**Re: Life Springs Christian Church
1130 Griegos Rd., NW
Traffic Circulation Layout**

Re: **Life Springs Christian Church**
1130 Griegos Rd.
Traffic Circulation Layout
Engineer's/Architect's Stamp 3-28-16 (F14-DQ58) ⁷³

Based upon the information provided in your submittal received 4-4-16, the above referenced plan cannot be approved for Building Permit until the following comments are addressed:

TRAFFIC CIRCULATION LAYOUT

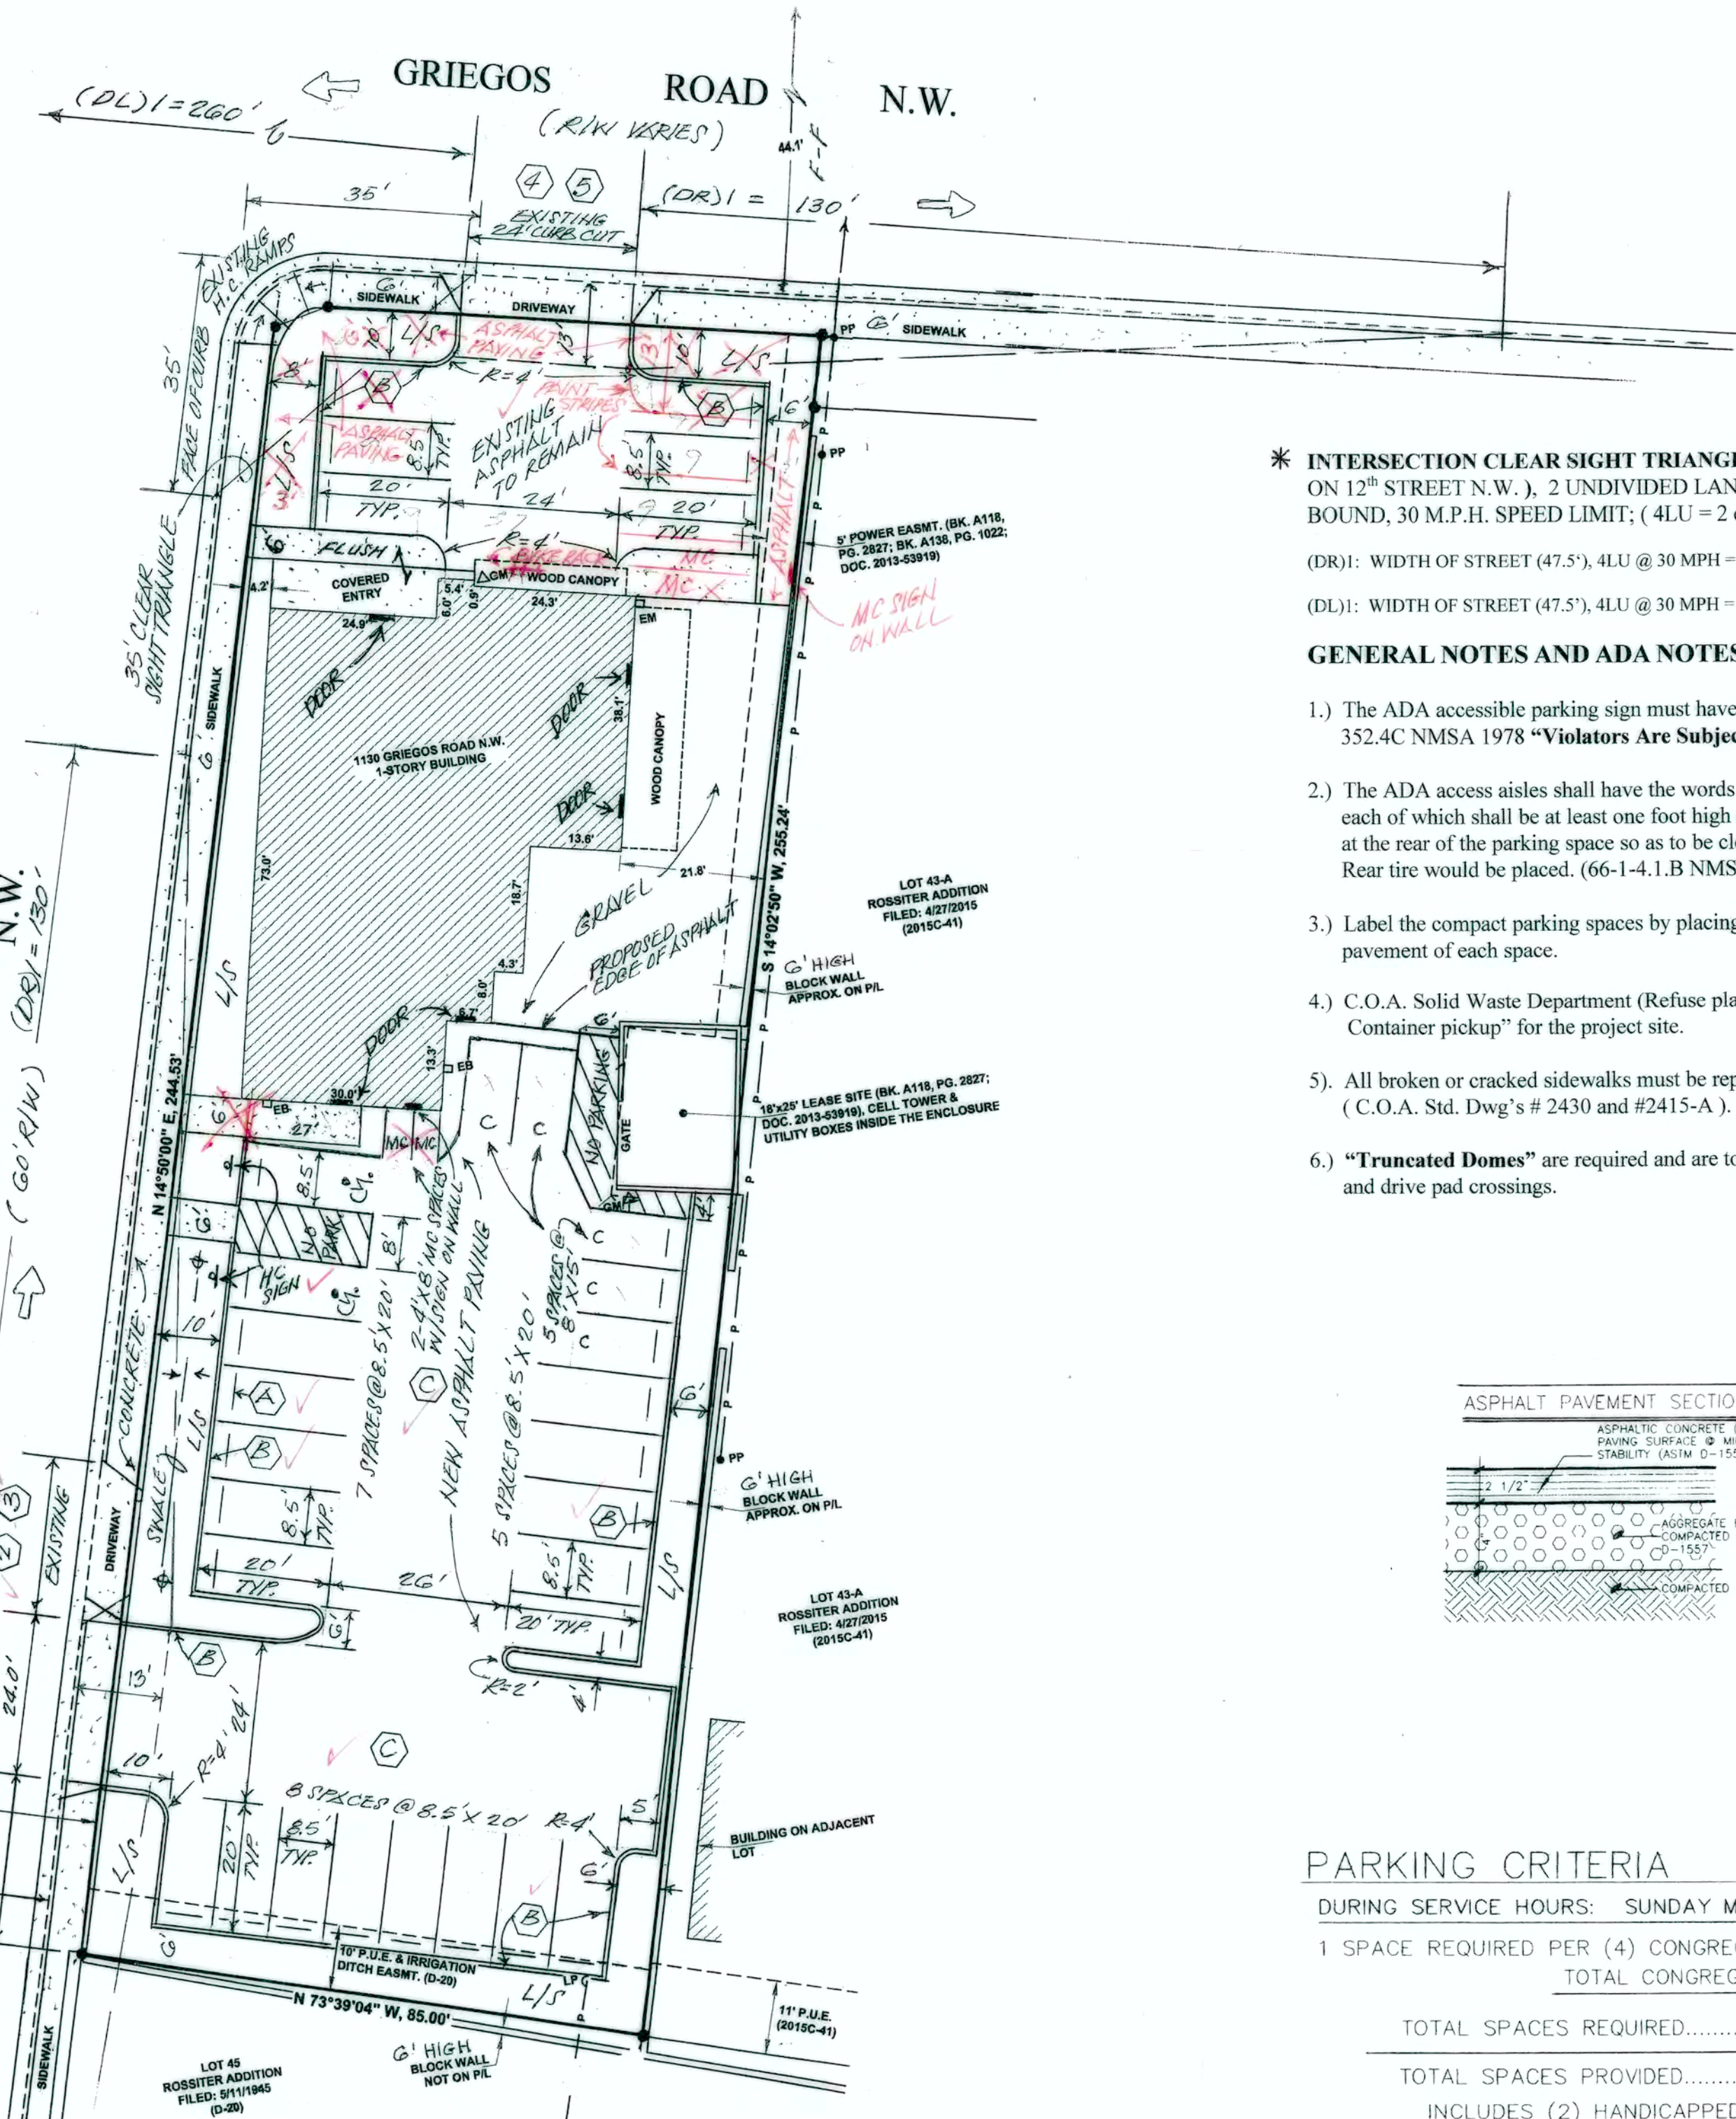
1. Please identify all existing doors, structures, sidewalks, curbs, steps and anything that influences the parking and circulation on the site.
2. Label the compact parking spaces by placing the words "**COMPACT**" on the pavement of each space.

3. Please detail all existing sidewalks and ADA ramps on 12th St. and Griegos Rd. Truncated domes are required at all public ADA ramps and drive pad crossings.

4. The ADA accessible parking sign must have the required language per 66-7-352.4C NMSA 1978 "**Violators Are Subject to a Fine and/or Towing.**" Please call out detail and location of HC signs.

5. The ADA access aisles shall have the words "**NO PARKING**" in capital letters, each of which shall be at least one foot high and at least two inches wide, placed at the rear of the parking space so as to be close to where an adjacent vehicle's rear tire would be placed. (66-1-4.1.B NMSA 1978)

6. Per DPM, a 6 ft. wide ADA accessible pedestrian pathway is required from the public sidewalk to the building entrances. Please clearly show this pathway and provide details from Griegos Rd. and 12th St. to the building entrances.

7. Per DPM, a 6 ft. wide ADA accessible pedestrian pathway is required from the HC parking stall access aisles to the building entrances. Please clearly show this pathway and provide details. In review of the submitted drawing, it appears that there is not a clear 6 ft. ADA pathway from the HC parking spaces to the building entrance.

8. Provide a min 6" or max 8" high concrete barrier curb or other acceptable barrier between landscaping and parking areas and/or drive aisles. Please call out detail and location of barrier curb.

9. Design delivery vehicle route needs to be shown.

10. Service vehicle and/or refuse vehicle maneuvering must be contained on-site; provide a copy of refuse approval. Please detail location of refuse container.

11. It is not apparent what type of pavement surface is being proposed at the south end of the project site. A hard driving surface will be required as part of this proposed project for parking area and drive aisles.

12. Please provide a sight distance exhibit (see the *Development Process Manual, Chapter 23, Section 3, Intersection Sight Distance*). Please provide this detail for entrance/exit off of 12th St.

13. Please add the following note to the clear sight triangle: "Landscaping and signage will not interfere with clear sight requirements. Therefore, signs, walls, trees, and shrubbery between 3 and 8 feet tall (as measured from the gutter pan) will not be acceptable in this area."

14. Unused curb cuts must be replaced with sidewalk and curb & gutter. A build note must be provided referring to the appropriate City Standard drawing.

15. All broken or cracked sidewalk must be replaced with sidewalk and curb & gutter. A build note must be provided referring to the appropriate City Standard drawing.
